From:
Sent: 17 September 2024 17:35
To: DC Admin
Cc:
Subject: Comments on application 2024/92167 Clayton Fields Development

Comments on application 2024/92167 Clayton Fields Development

Project
Proposed Residential Development
Clayton Field
Edgerton
Huddersfield

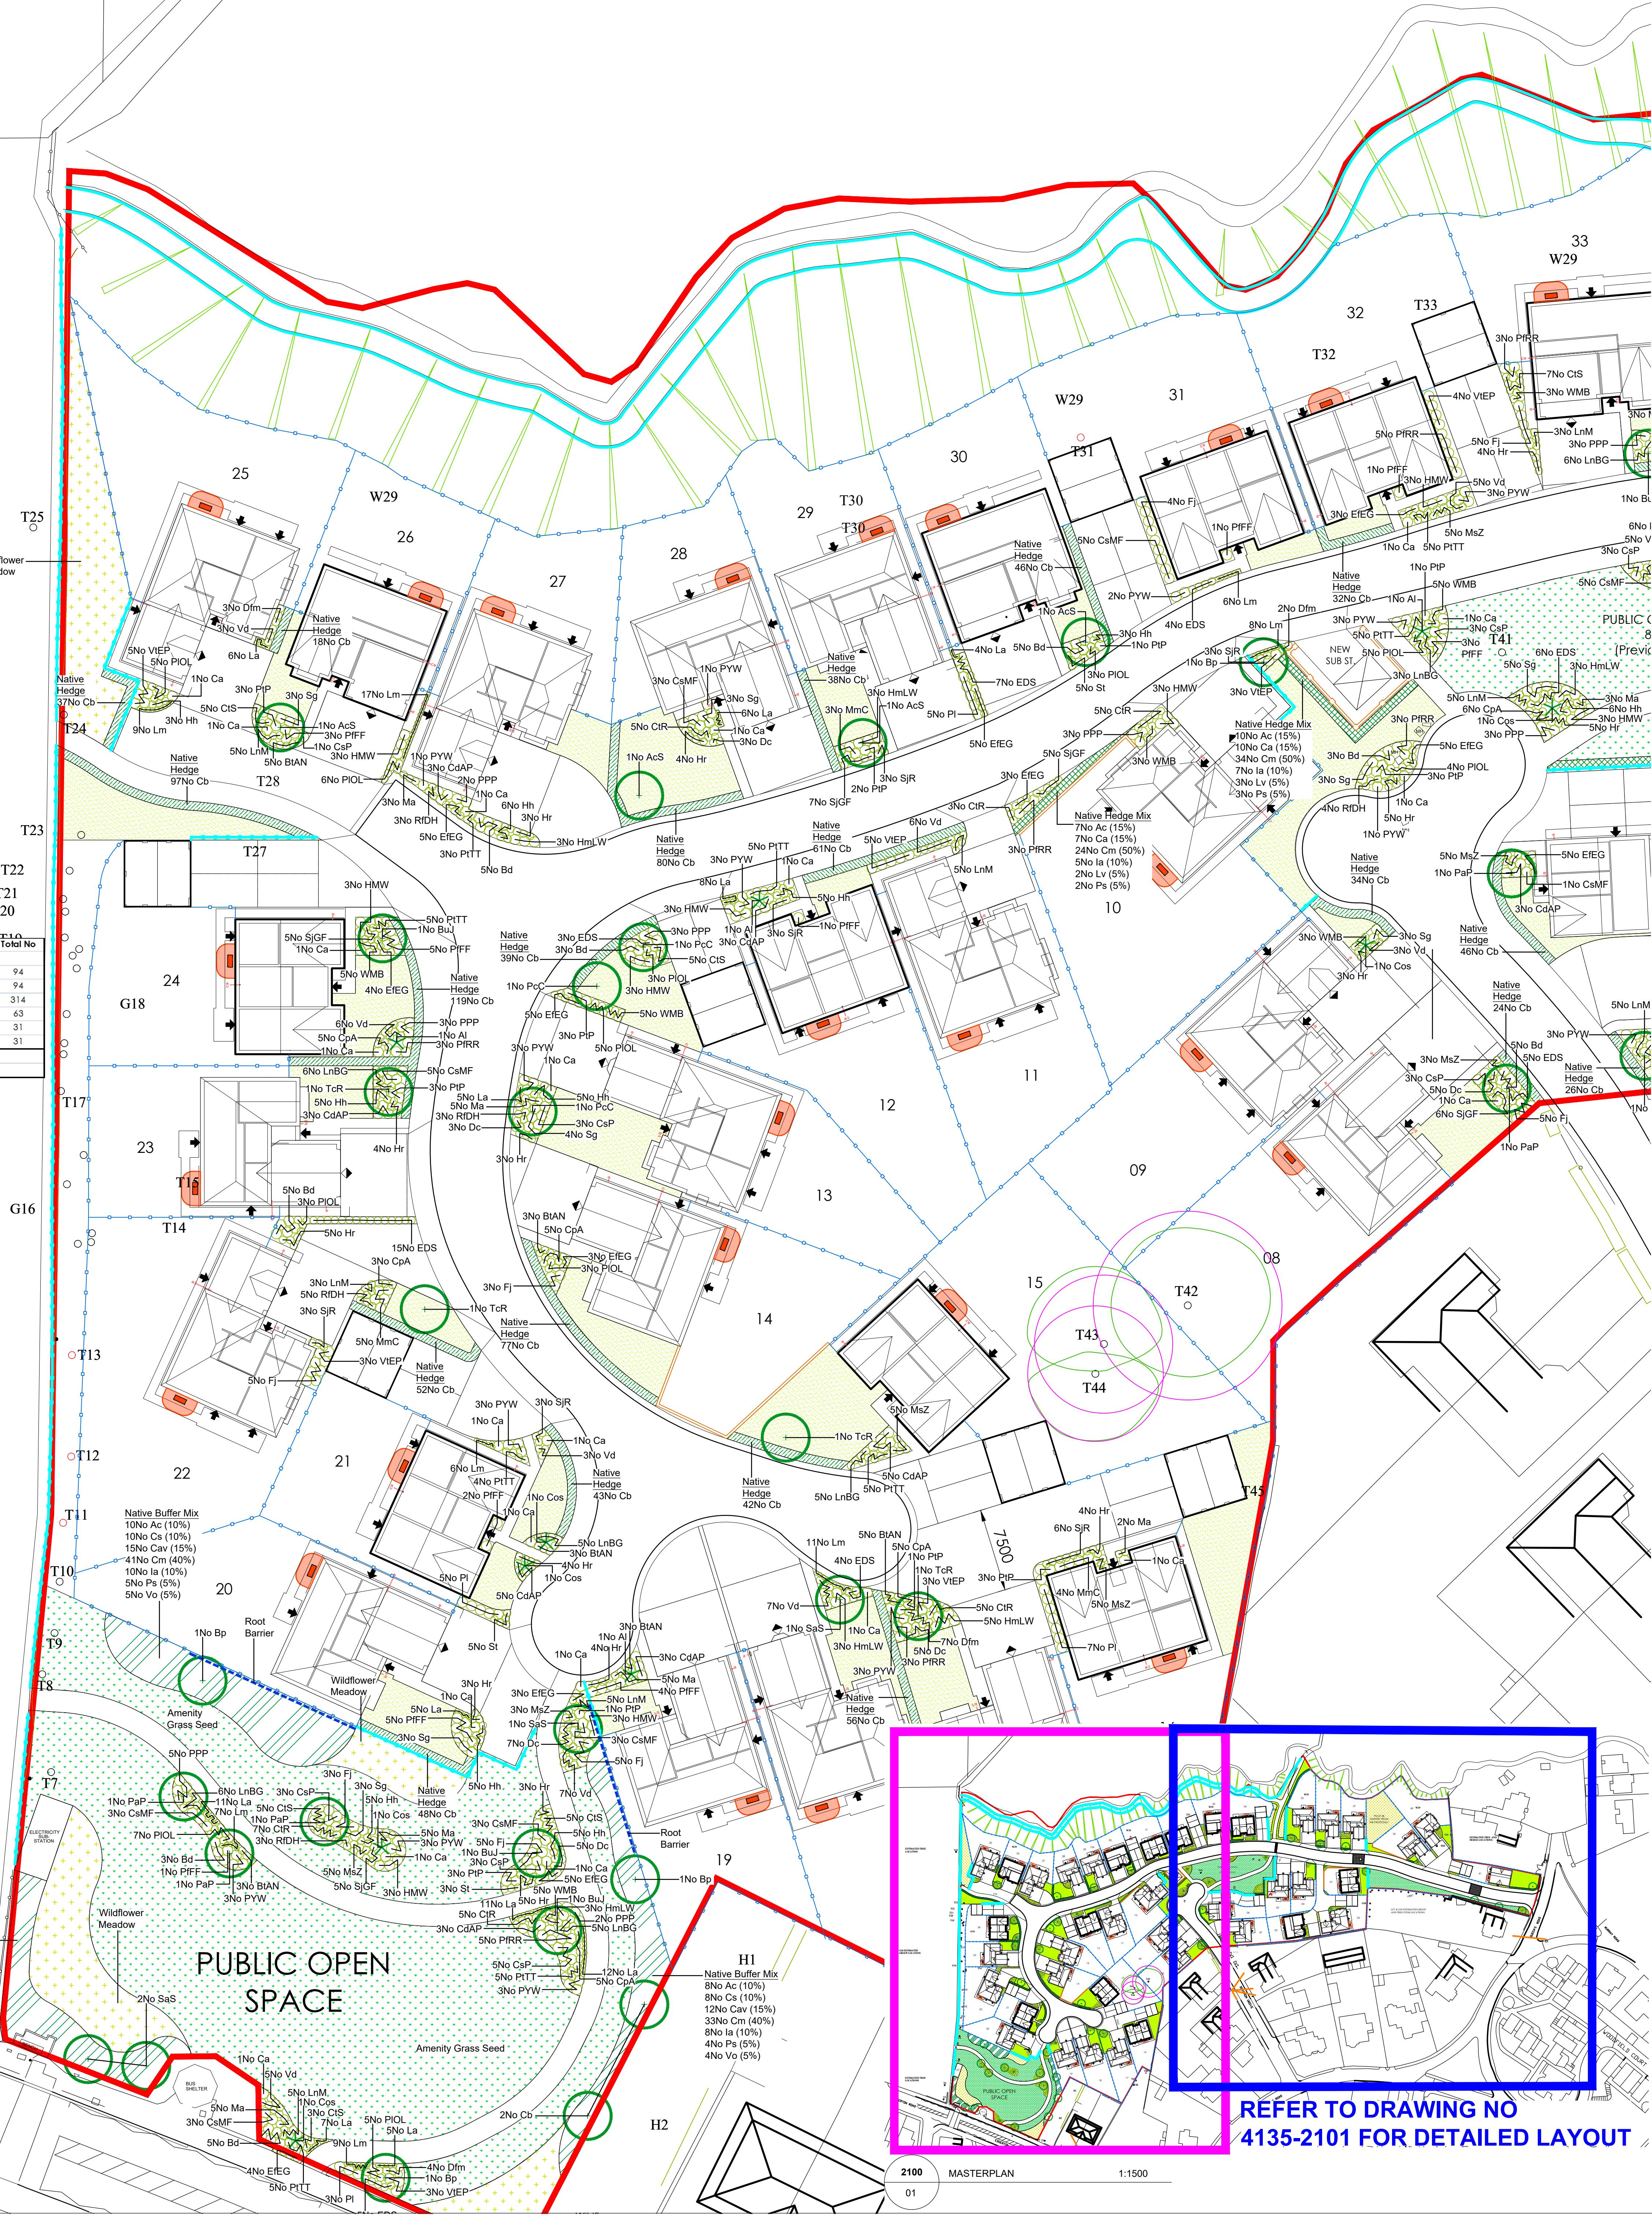
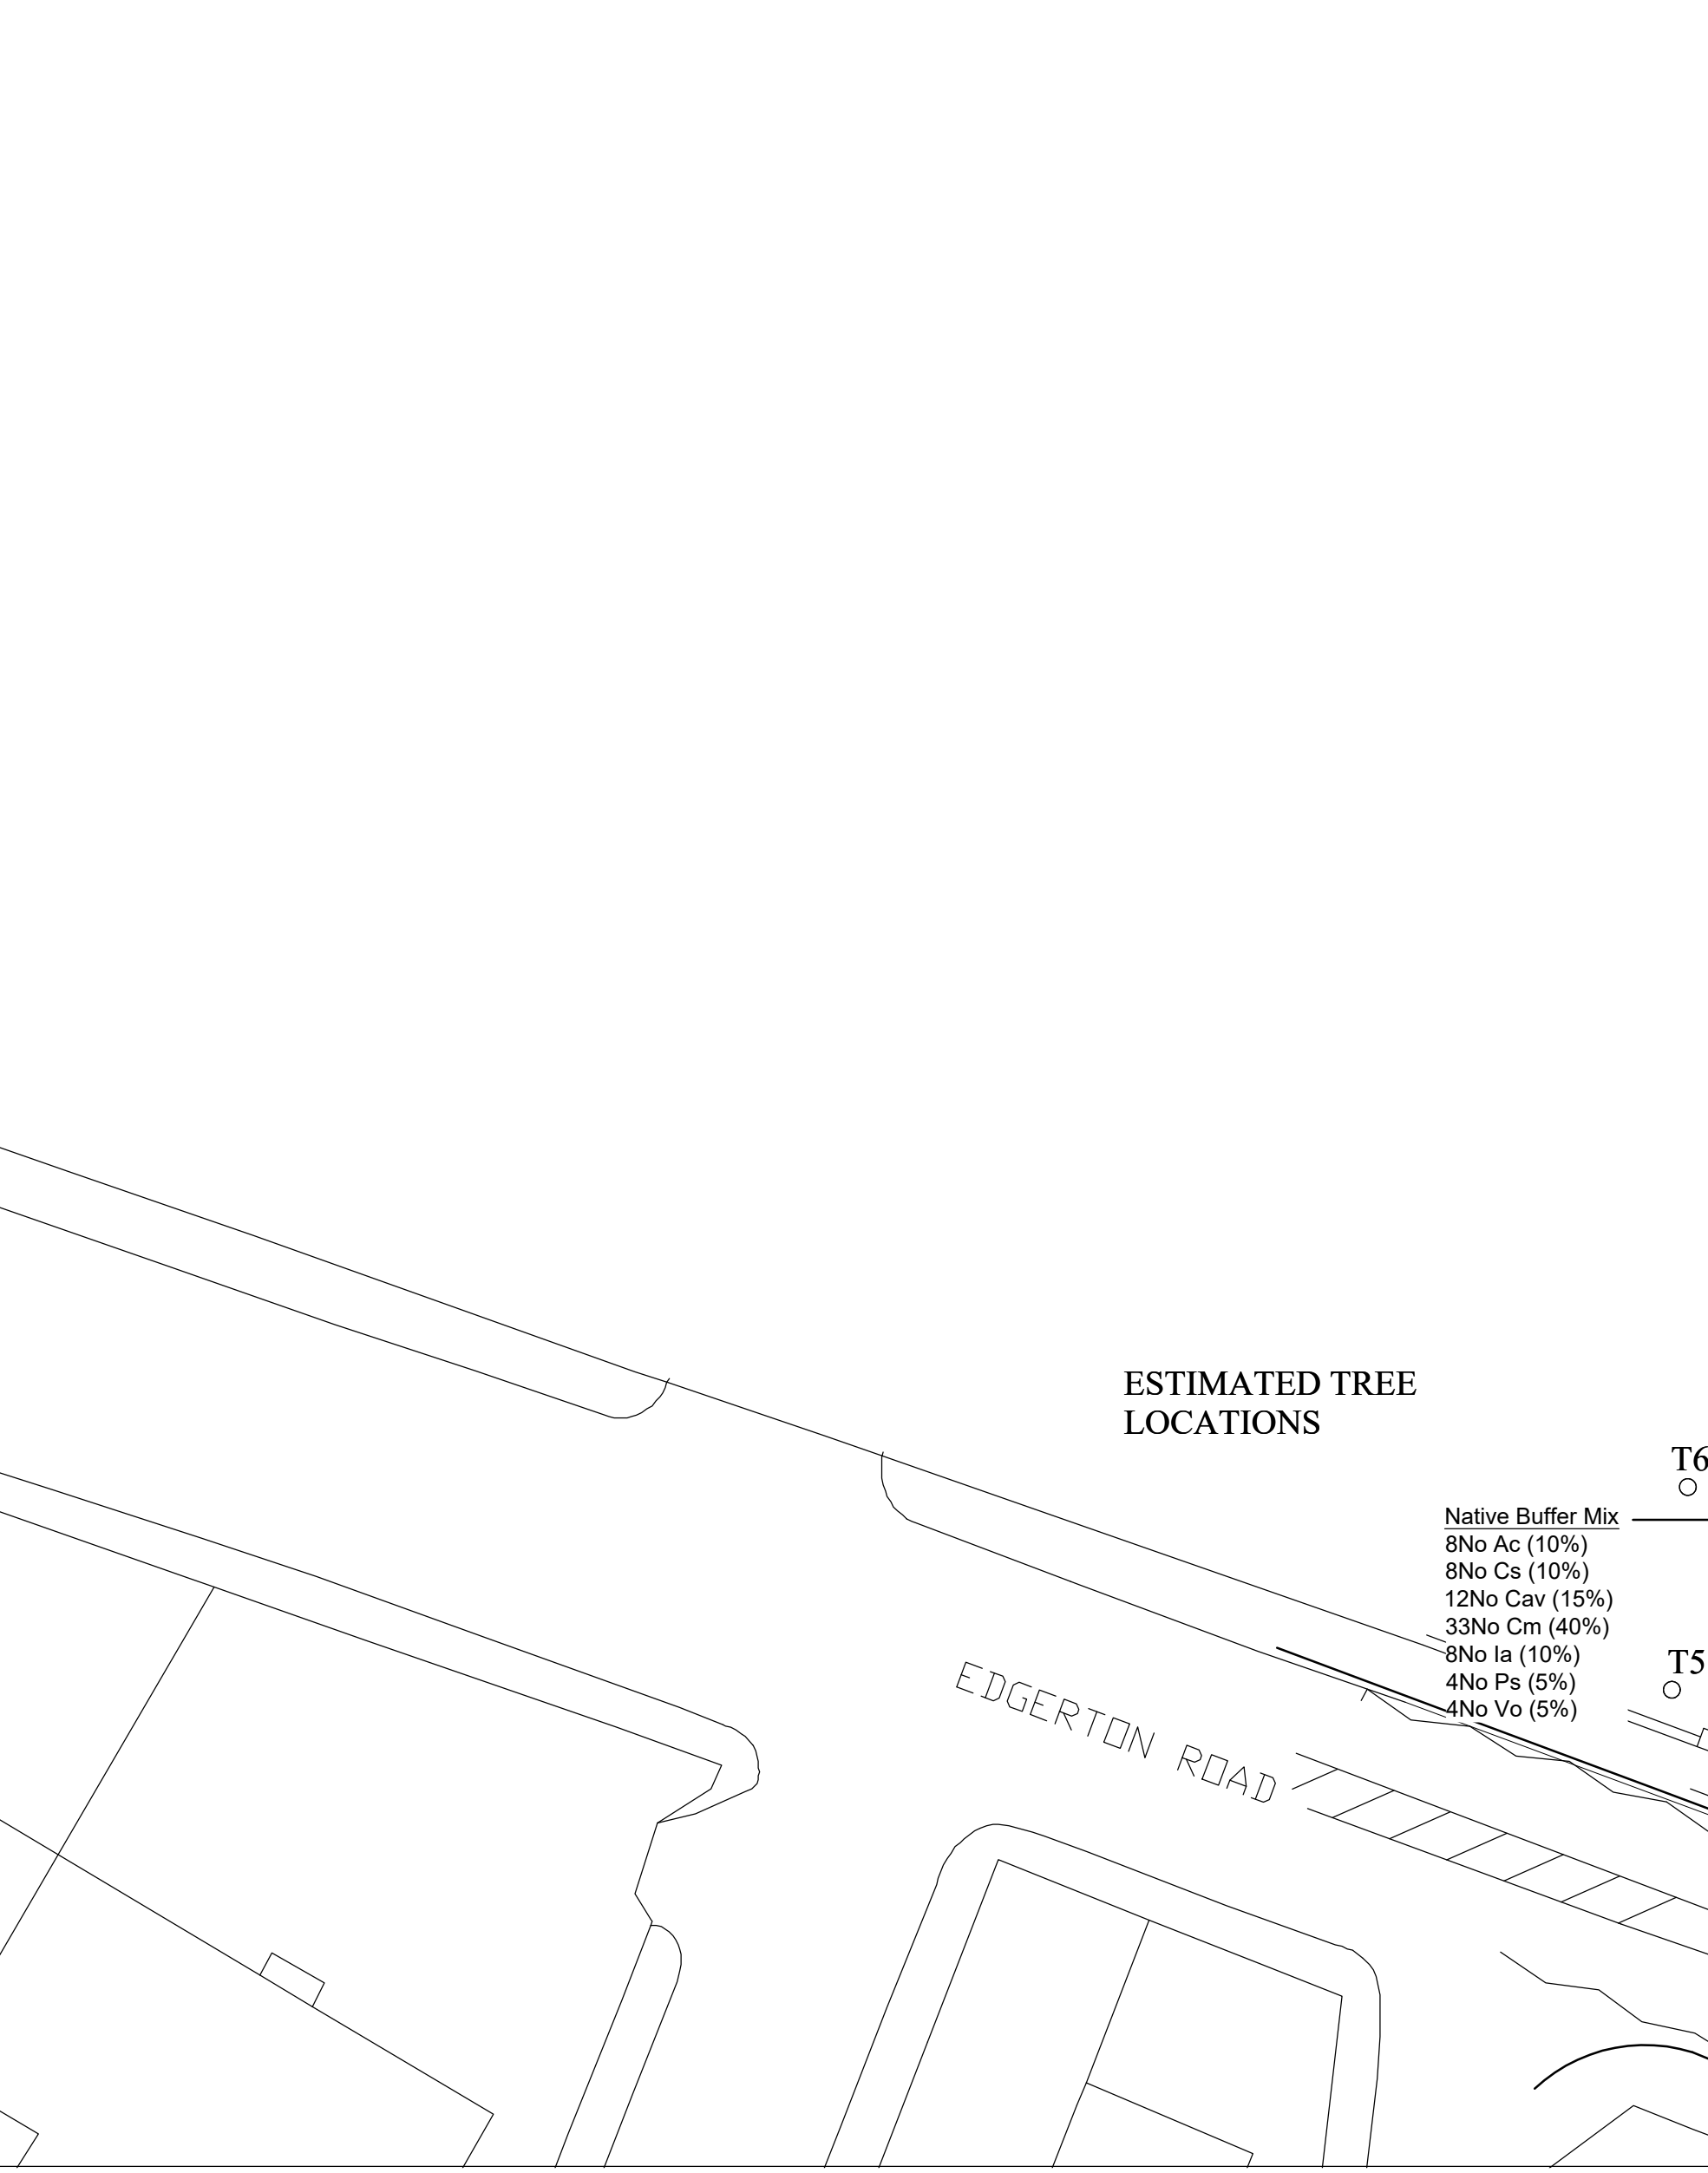
3. Adverse impact on protected Trees and Fauna: The development as shown neglects the Tree Preservation Orders and sees the removal of some beautiful old trees. As they have been standing for nearly a hundred years, they are home to a large ecosystem of fauna. It's utterly disgusting that the plans do not respect this but aim for cheap profit rather than fitting in with the landscape and fauna. Especially in the case of protected species, developers and Councils are instructed to avoid harm and disturbance of protected species. The removal of the trees, e.g. T43 and T44 seem simply for profit and with no good reason. This is removal of a habitat for no good reason.
